**SECTION 4.55(1A) MODIFICATION APPLICATION – SSD 9670 MOD 5  
WESTERN SYDNEY UNIVERSITY INNOVATION HUB – 2-6 HASSALL STREET, PARRAMATTA**

This application is the fifth modification to the consent and is known as MOD 5. The application proposes to amend Condition A2 in relation to minor adjustments to the location and dimensions of the northern and western signage zones in order to accommodate the final design of the Western Sydney University building identification signage. This signage is proposed to be installed in accordance with Condition A29.

Sheet Name
NORTH ELEVATION

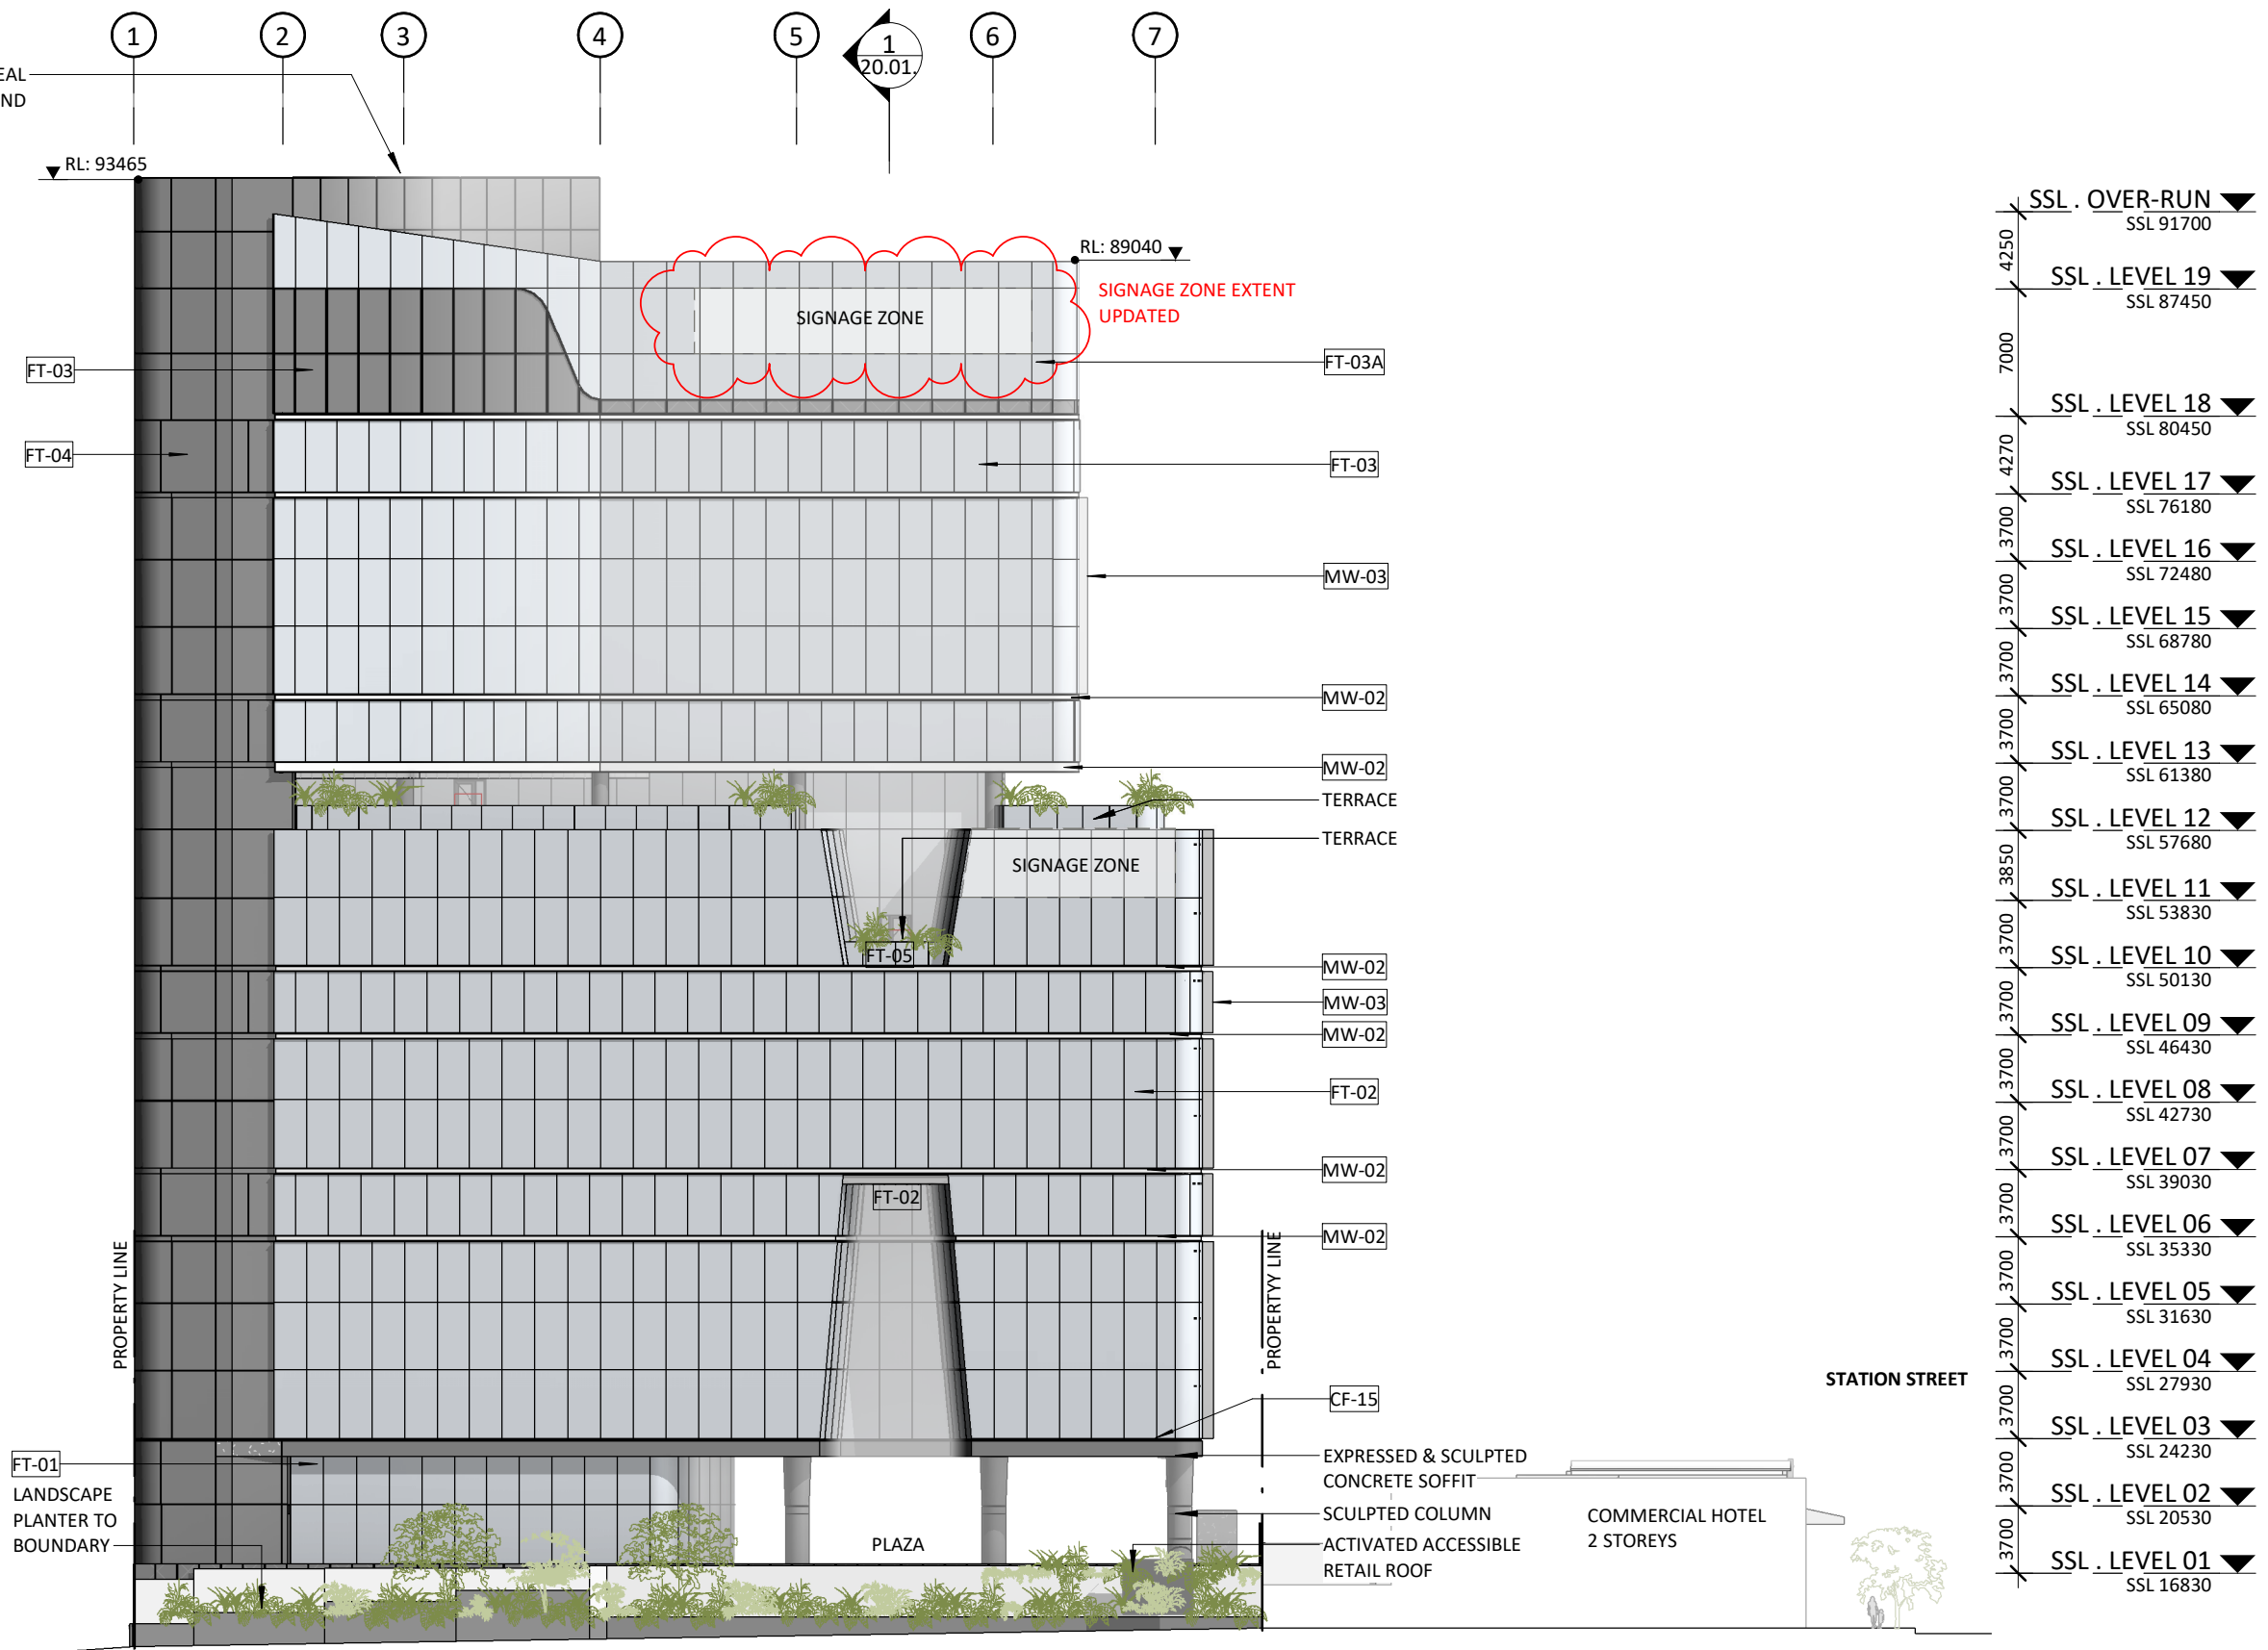
The proposed modification to development consent SSD 9670 seeks to make minor adjustments to the dimensions of two (2) signage zones, being:

- One (1) on the Northern Elevation within the building parapet; and
- One (1) on the Western Elevation within the building parapet.

These signage zones are required to be amended in order to accommodate the final design of the Western Sydney University building identification signage.

Architectural Plans prepared by Tzannes Blight Rayner			
Dwg No.	Rev	Name of Plan	Date
30.00	<del>LO</del>	North Elevation	<del>09.08.2019</del> <b><i>10.12.2020</i></b>
30.03	<del>LO</del>	West Elevation	<del>09.08.2019</del> <b><i>10.12.2020</i></b>
